EAST END ROAD SECTION 73 DOC

This document has been prepared by Downen Farmer Architects on behalf of Manak Homes to support a Section 73 Application for the proposed development at Land Rear Of The Bobath Centre, 250 East End Road, London, N2 8AU.

The rationale of the document is to detail and explain the minor amendments proposed to the scheme, as approved by applications 21/2602/FUL and 23/3838/NMA.

03 Third Floor Plan  
1:100

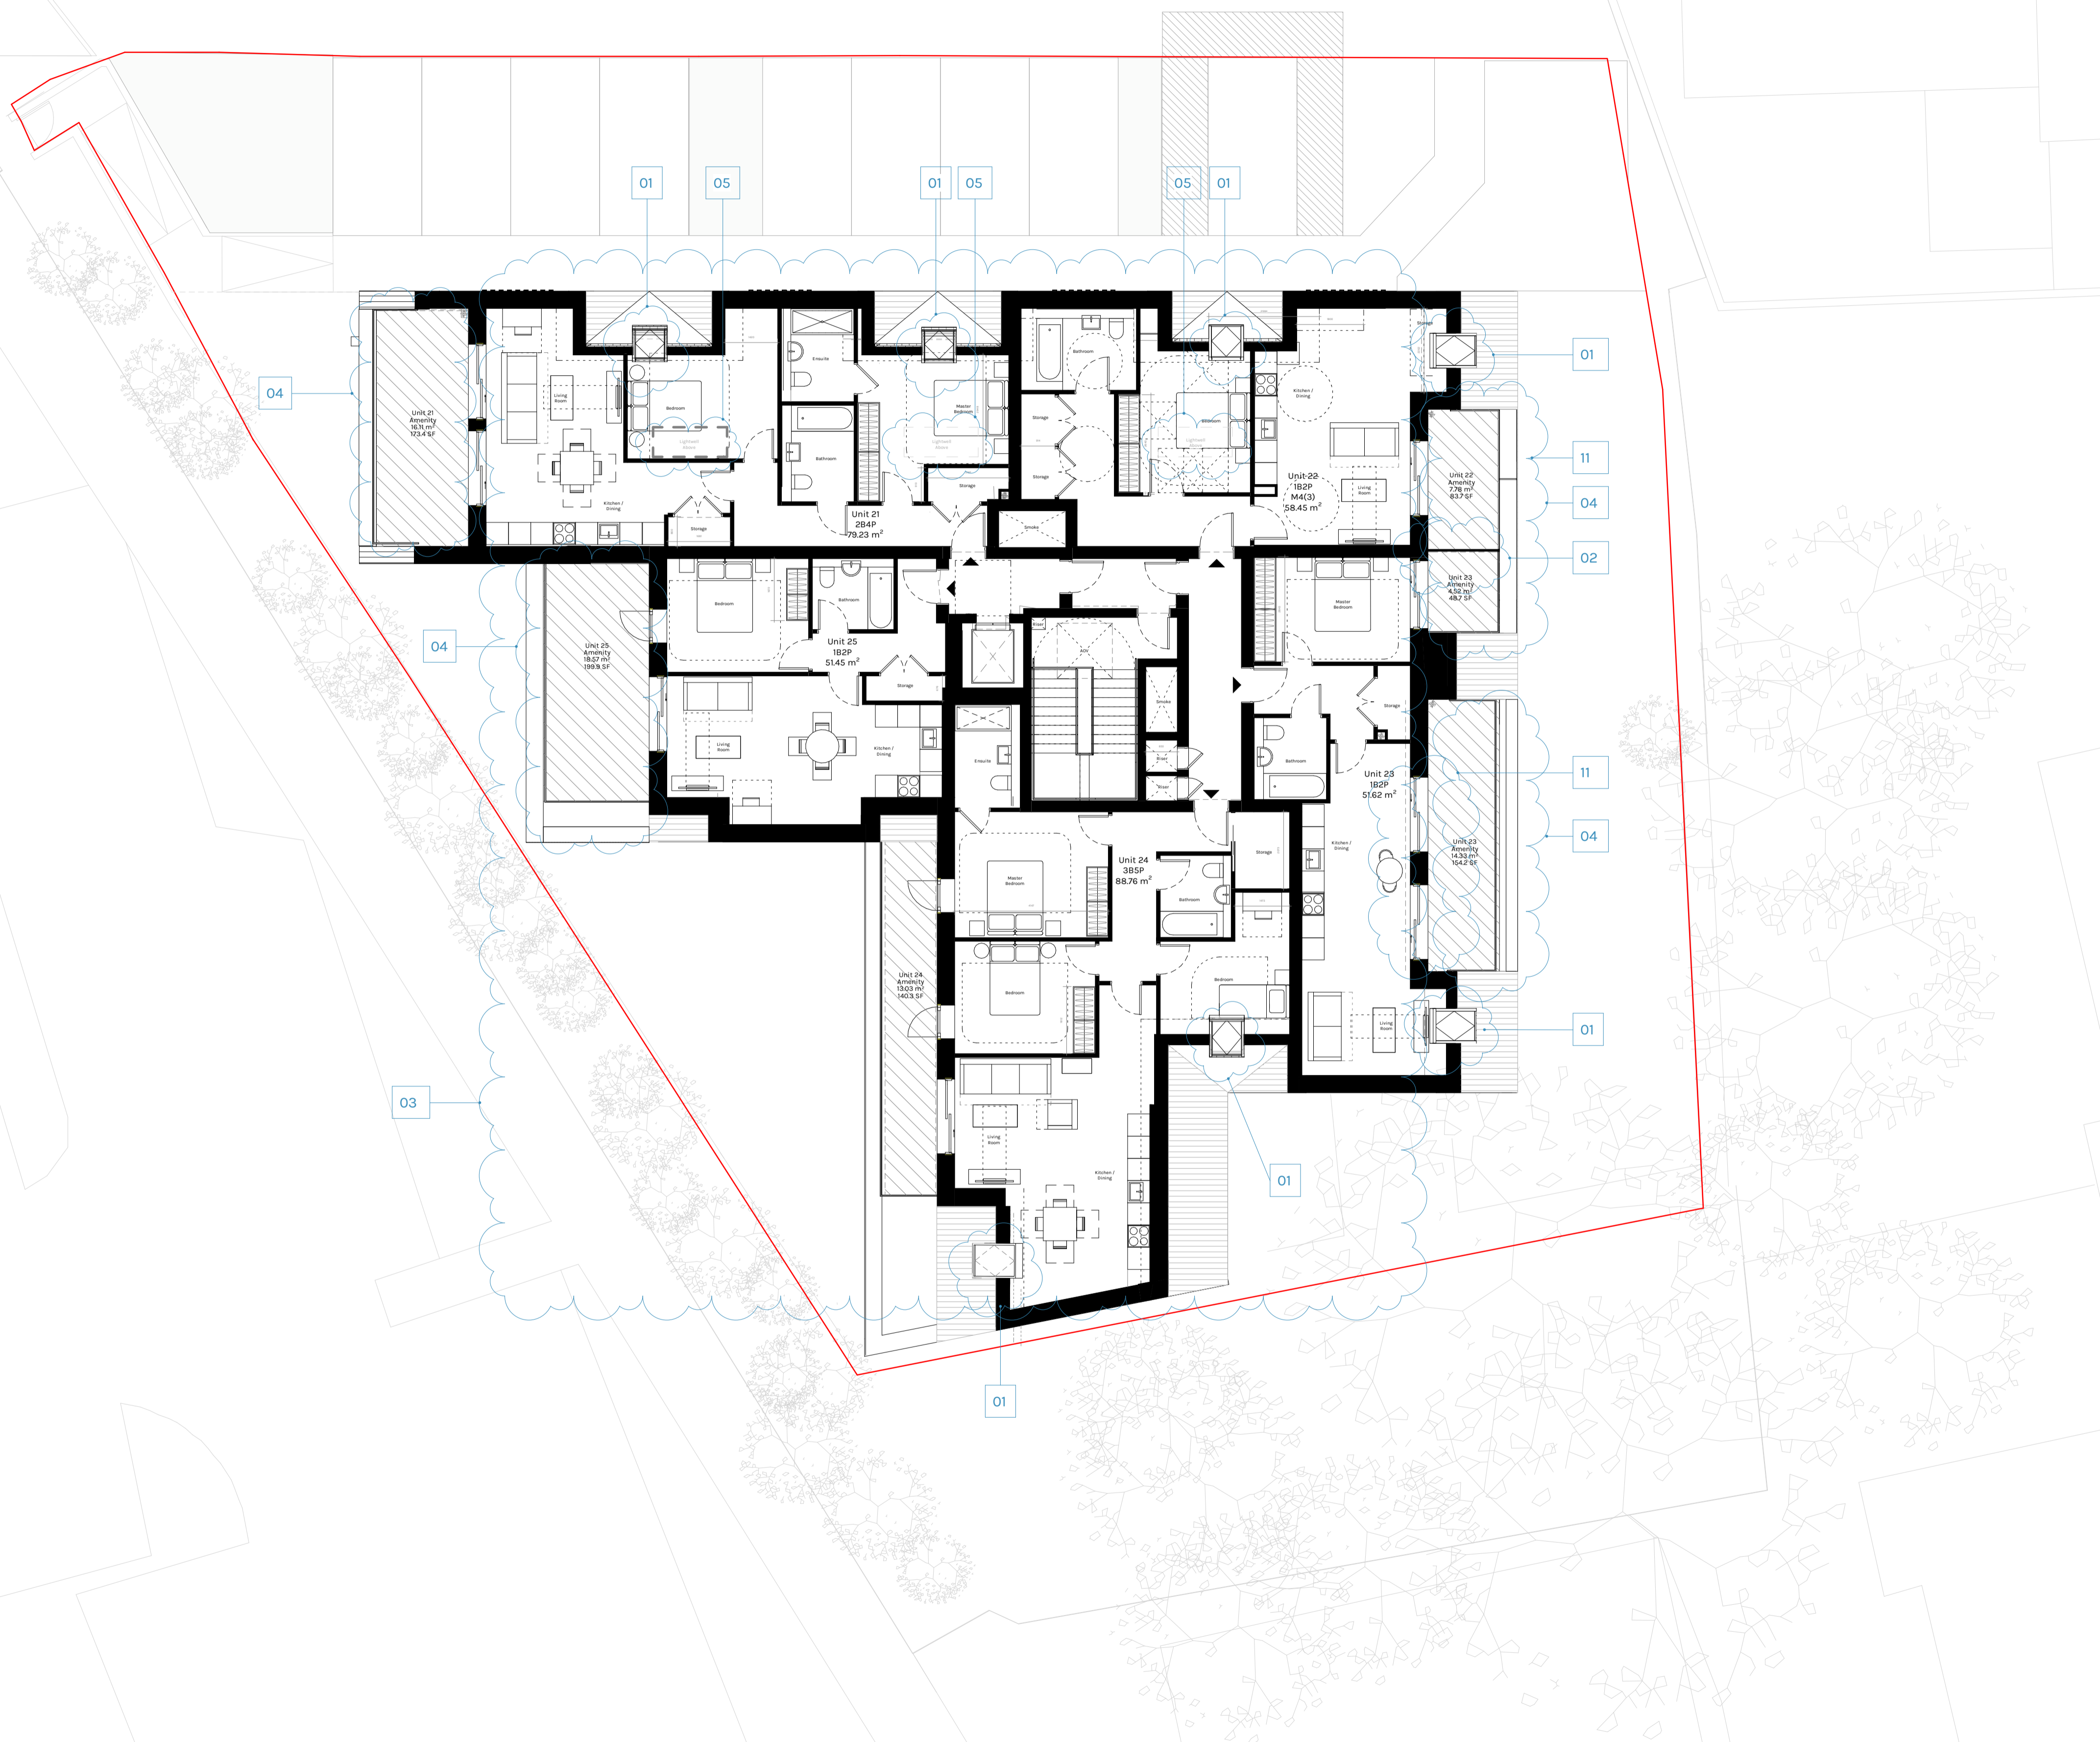
The amendments made to the previously approved application have been undertaken in order to rationalise and improve the interior layouts of the third floor units by adding roof-lights within the pitched roof and to increase the size of the private amenity terraces on level 03.

- REVISIONS KEY**
- 01 Roof-lights added within the pitched roof at Level 03 to create better quality residential accommodation.
 - 02 Privacy screening added to separate external amenity areas between units.
 - 03 Layout of residential accommodation revised to improve quality of the space.
 - 04 Terraces (level 03) revised and area increased to improve layouts and facilitate drainage.
 - 05 Position of approved Light well in the Green Roof revised and 2 new Light wells added to improve the daylighting to the bedrooms below.
 - 06 Roof Shape Revised to create better quality accommodation.
 - 07 Lift overrun added.
 - 08 Smoke shaft overrun added.
 - 09 Balcony position amended to serve living room instead of bedroom.
 - 10 Addition of 2 new windows on the South-East Facade.
 - 11 General window amendments - Variation in size
 - 12 Edge Protection to AOV added
